**Memo**

**Date:** 3/30/2015  
**To/Company:** Steve Wolgin, USREA  
**Project:** USREA Dreamport  
**From:** Becca Casey  
**Pages:**  
**RE:** Code questions re: Pearl Tap Room to expansion to Second Floor

**Overview** Pearl Tap Room, located at 444 Fore Street plans to re-occupy the floor above for a lounge area. This would include re-opening an area of the floor above that is currently closed as a raised ceiling area (above the rear portion of the first floor), as well as using the existing stair at the Wharf Street end of the space for access.

JOB NAME: PEARL TAP HOUSE

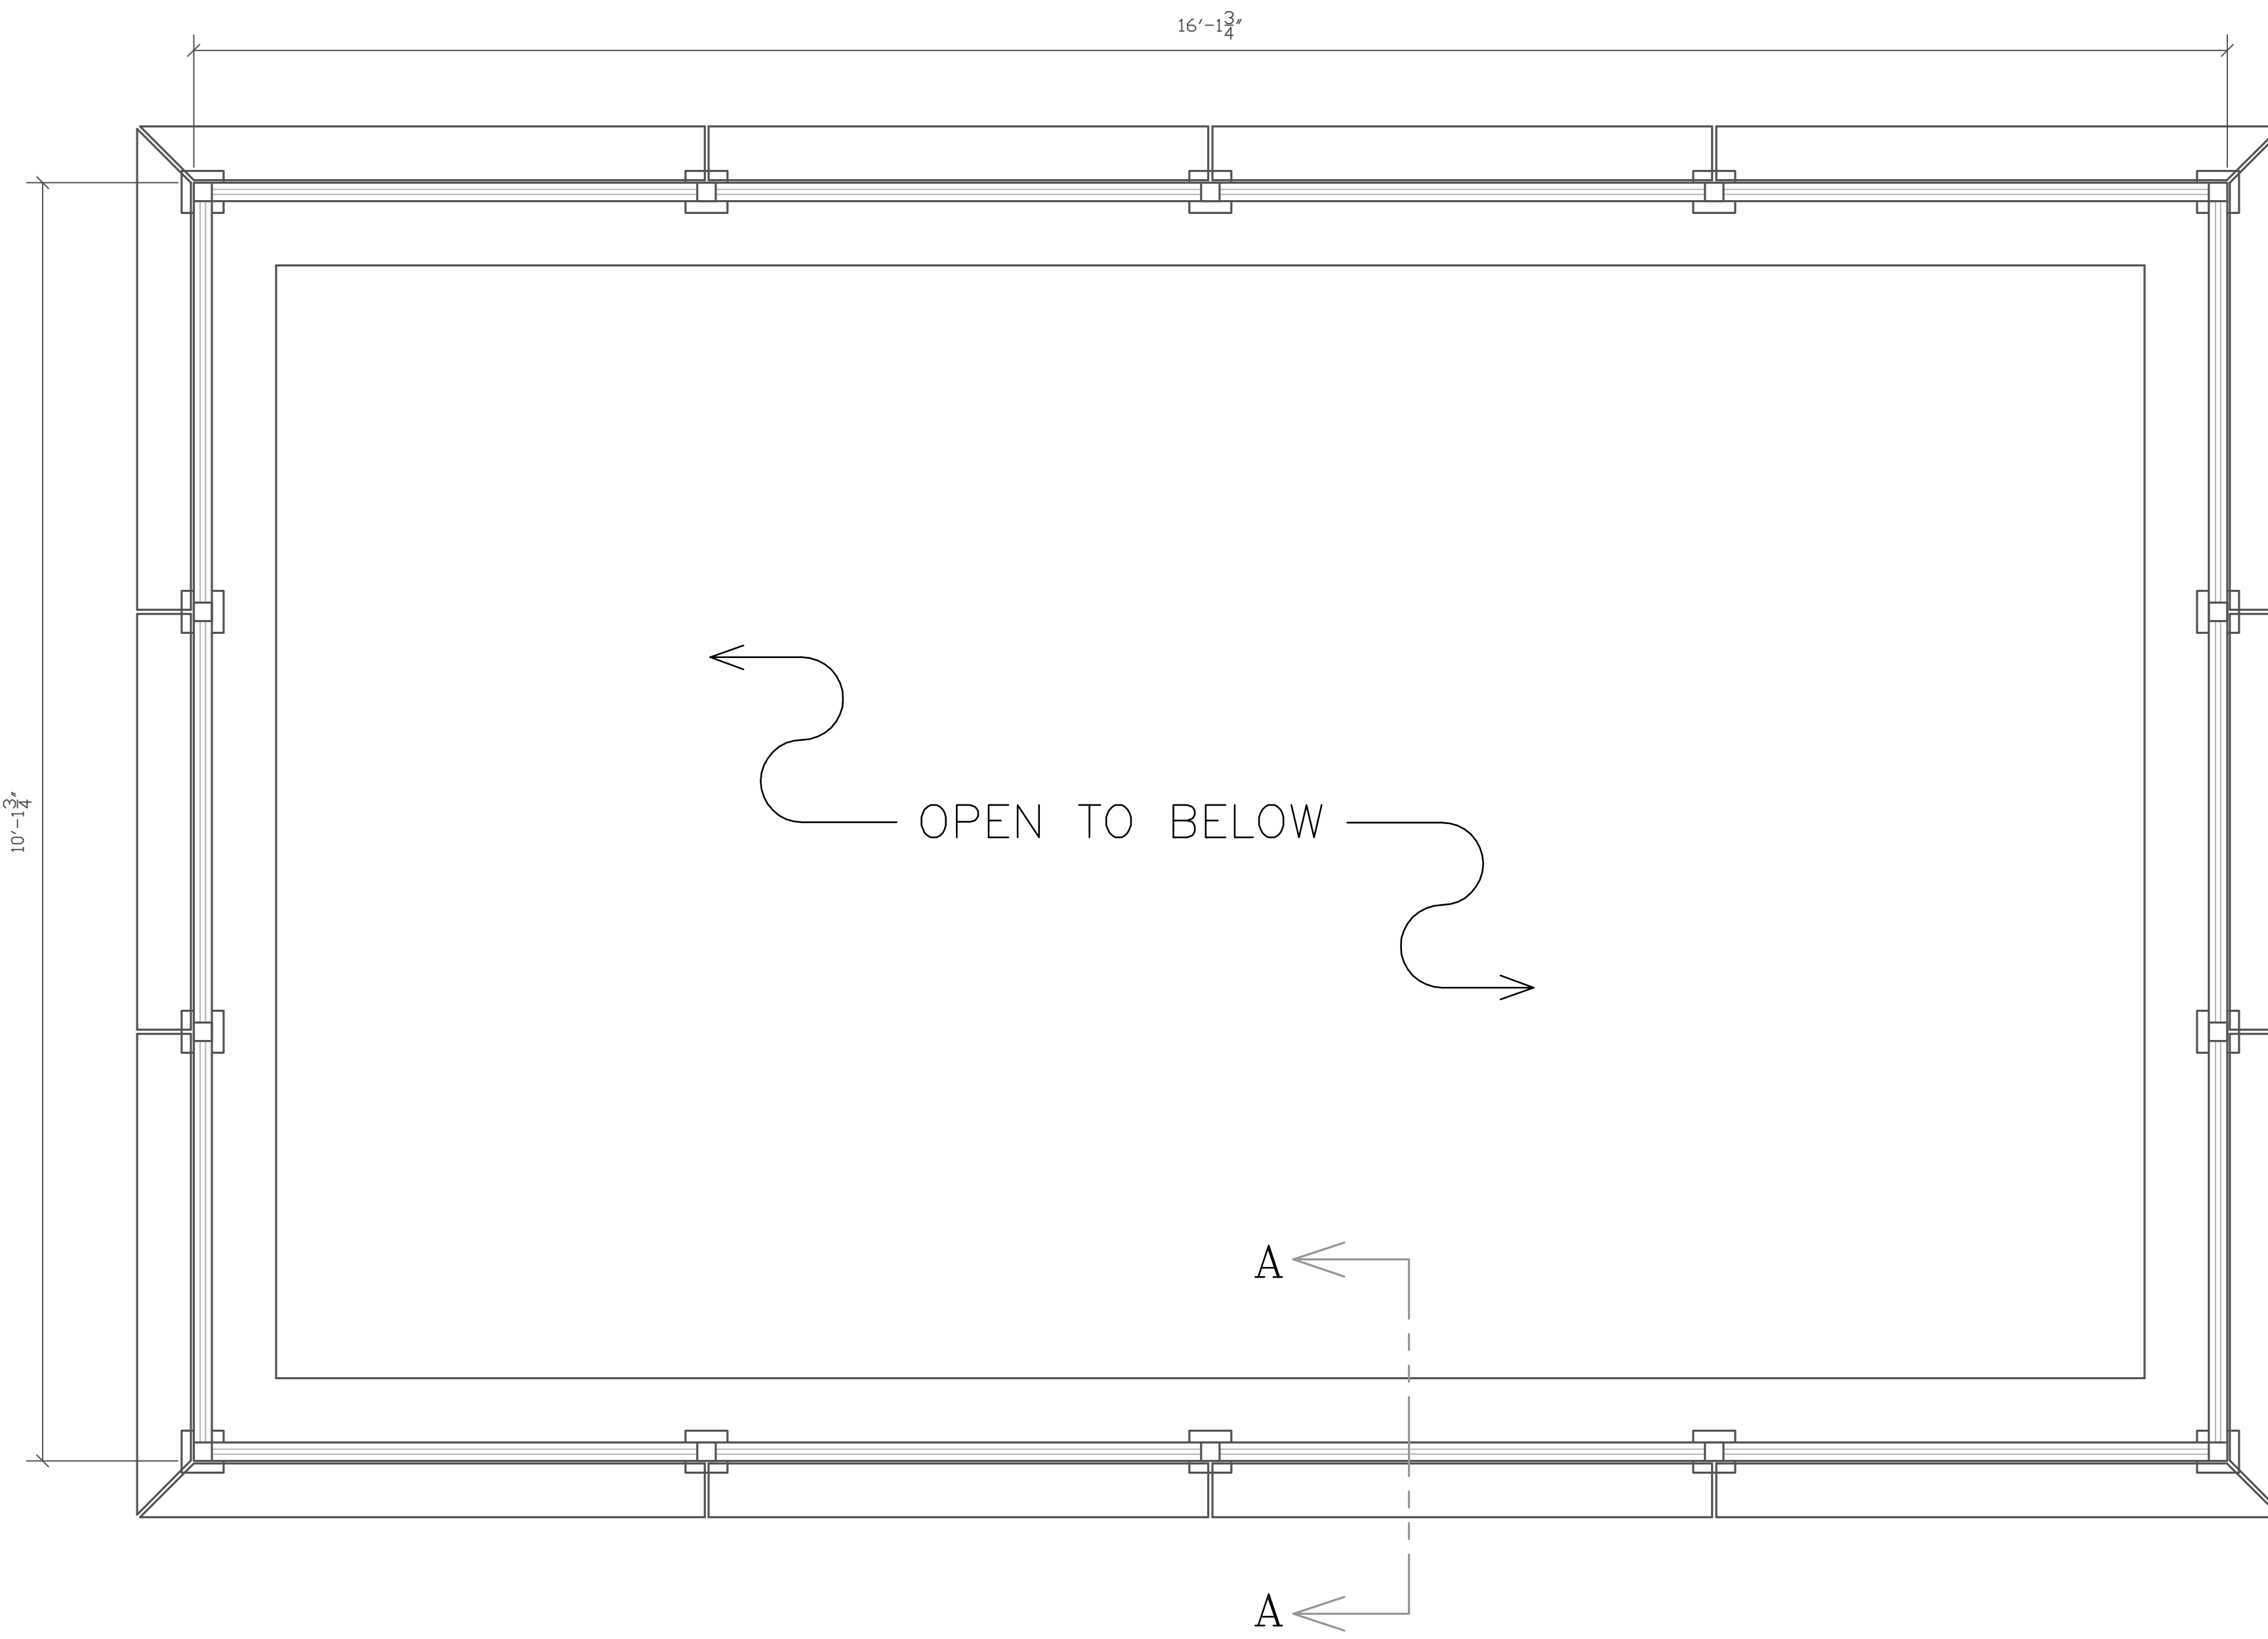
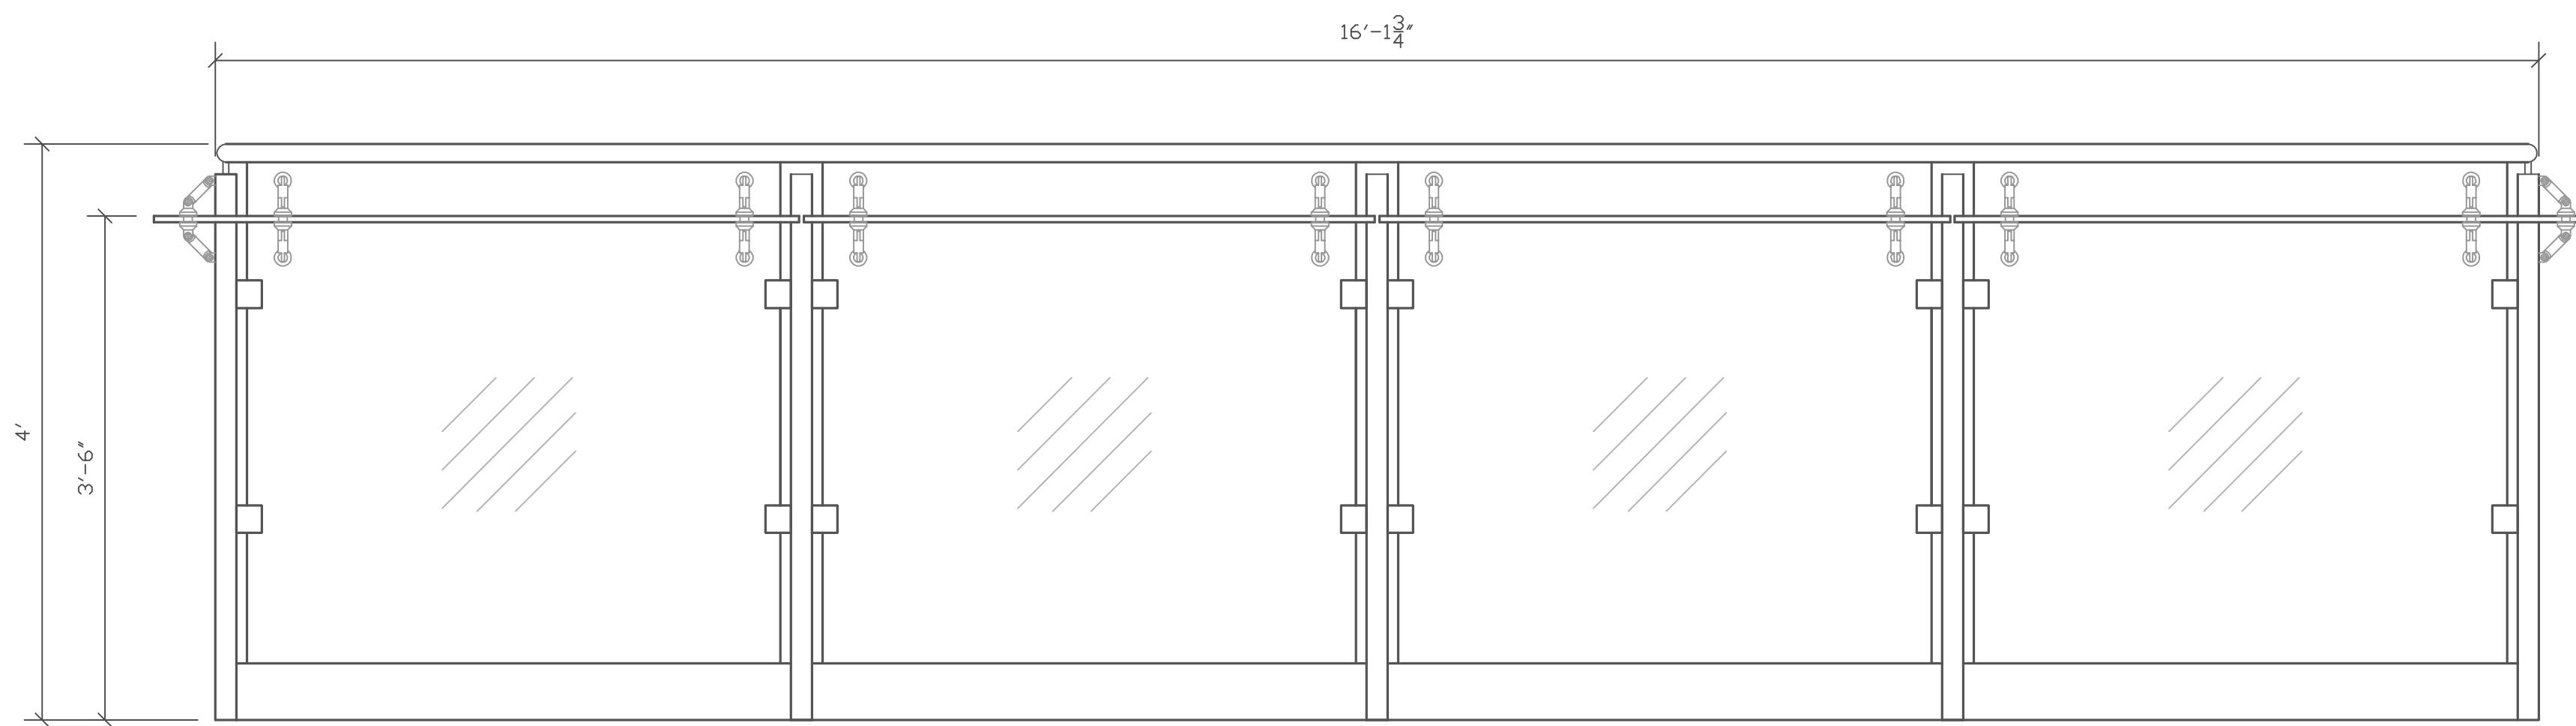
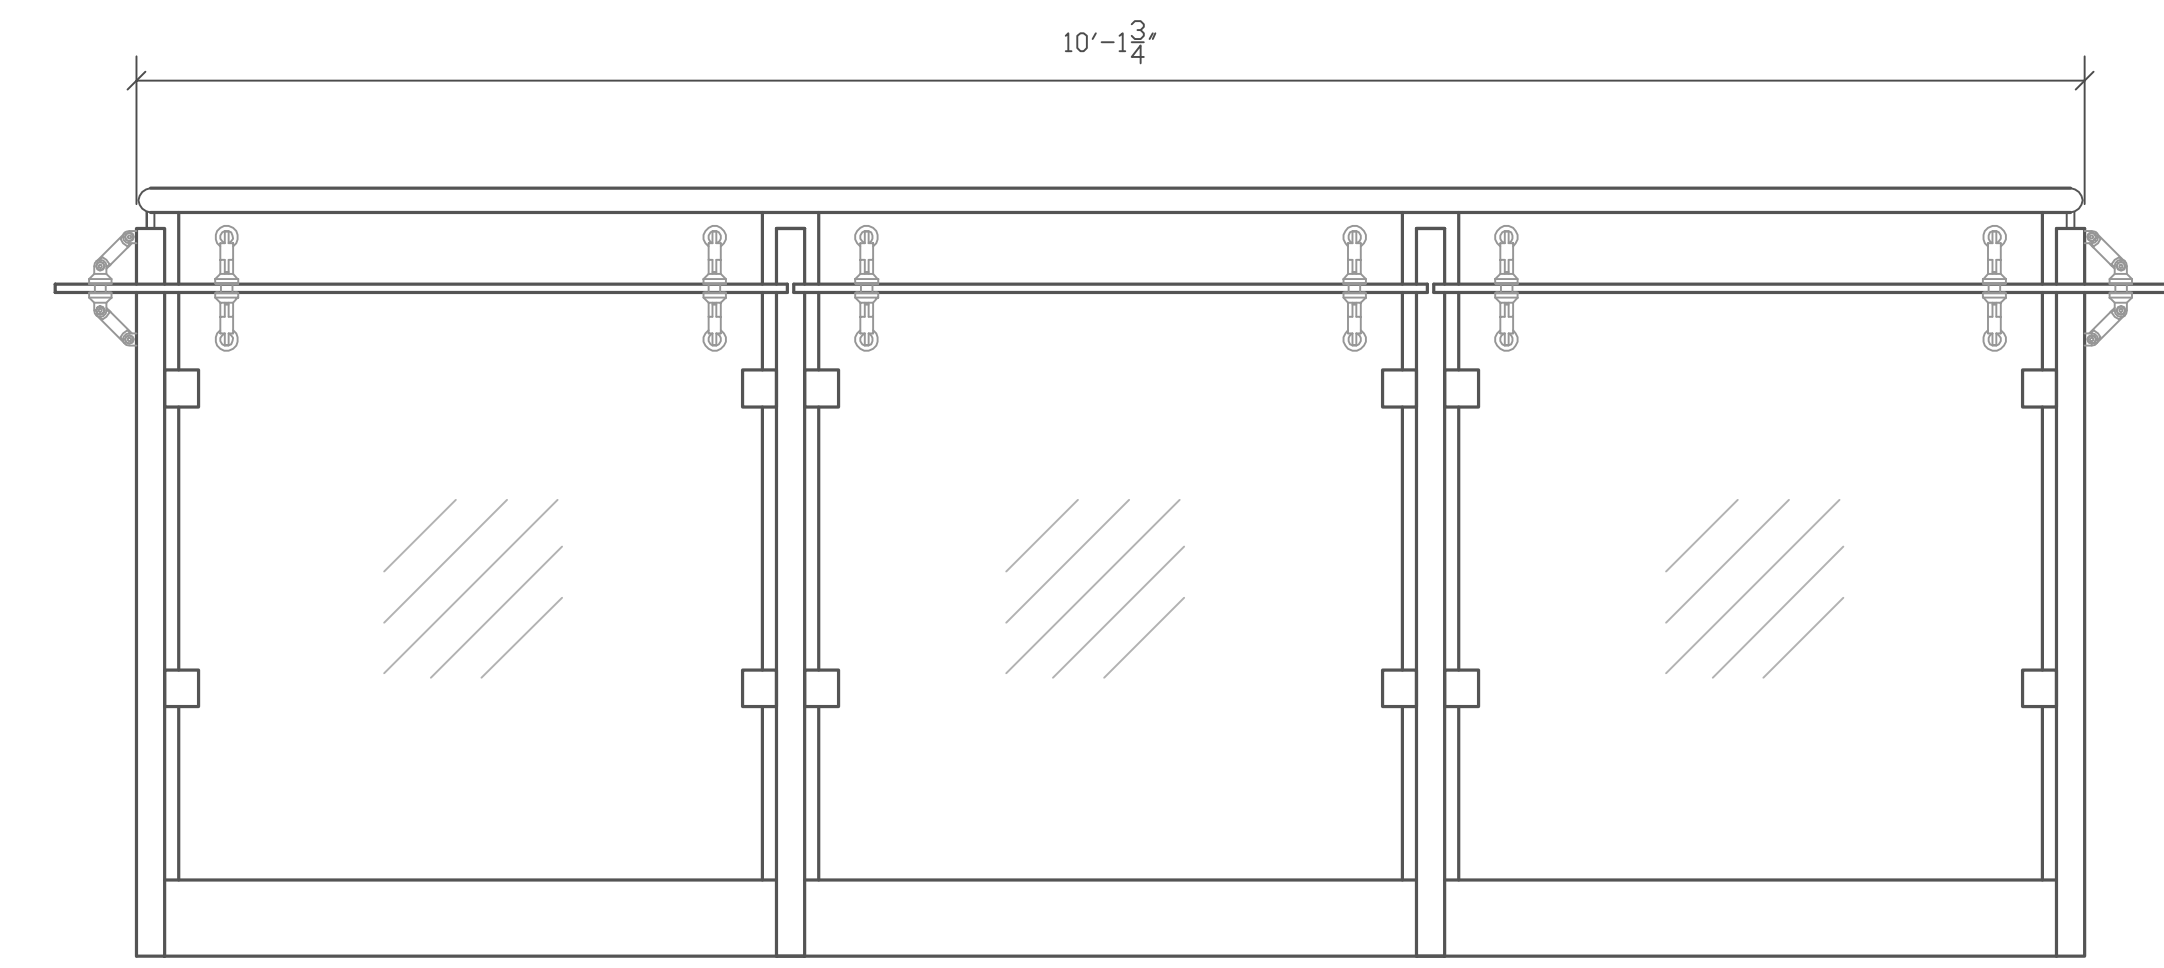
**Multi-Level/Opening** Re-instating the balcony opening from second floor; scope would include, but not be limited to: removing existing raised platform/ceiling area, infilling low walls at perimeter of opening.

- Per NFPA 101; 8.6.8.2 "Convenience Openings" are permitted, but shall not connect more than two adjacent stories, nor serve as a means of egress (and other conditions n/a to this project).
- Confirm fire separation of construction to dwelling units above 2<sup>nd</sup> floor is intact; upgrade/repair as necessary.
- Architect advises top of wall design be such that drinks cannot be set on ledge.
